From: John Flanigan <John.Flanigan@randwick.nsw.gov.au>
Sent: Thursday, 28 January 2021 11:23 AM
To: Candice Pon
Subject: RE: Modification 1 Stormwater OSD Modification(SSD-9649-Mod-1)- Reminder of Due Date for Response to Planner
Attachments: D03887922 SSD 9649 Development Consent 4-18 Doncaster Avenue - F2017-00269.pdf

From: John Flanigan <John.Flanigan@randwick.nsw.gov.au>
Sent: Thursday, 28 January 2021 4:59 PM
To: Candice Pon
Subject: SSD 9649 Doncaster Ave Modification

From: John Flanigan <John.Flanigan@randwick.nsw.gov.au>
Sent: Monday, 1 February 2021 2:23 PM
To: Candice Pon
Cc: David Meredith
Subject: FW: SSD 9649 Doncaster Ave Modification
Attachments: Appendix D - Arborist Assessment (1).pdf; D03887922 SSD 9649 Development Consent 4-18 Doncaster Avenue - F2017-00269 (002).pdf

Figure 1 Shows the locations of both the existing and proposed stormwater pipe.

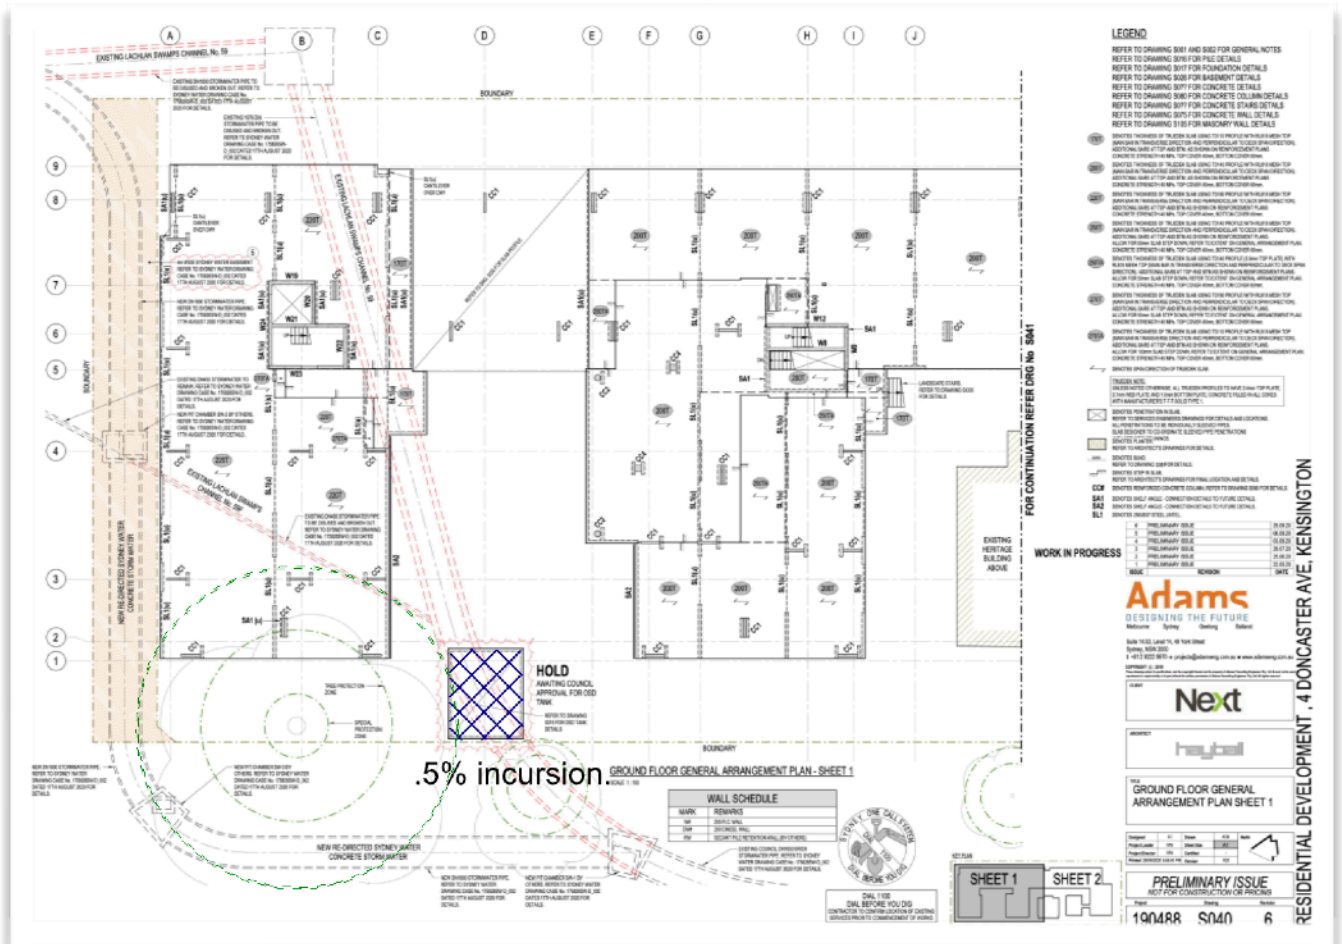
- 1. All plans must now include measurements (in millimetres), showing the 10m distance that will be provided between the centre of its trunk and this new 5m x 4m OSD tank;**
- 2. The applicant must fully document the system that will be used for shoring up the exposed soil profile during this component, as this is critical to preventing 'over-excavation', which would be harmful to the tree as it would result in works being performed closer to the tree than intended. Sections 1.2 & 6.2 - 6.3 of the Report refer to this exact issue as possibly the main concern, but then no specific recommendations have been provided for this component;**
- 3. The applicant must ensure that all of the other Tree Management Recommendations that are listed at Section 7 of the Report are incorporated as conditions into any consent.**
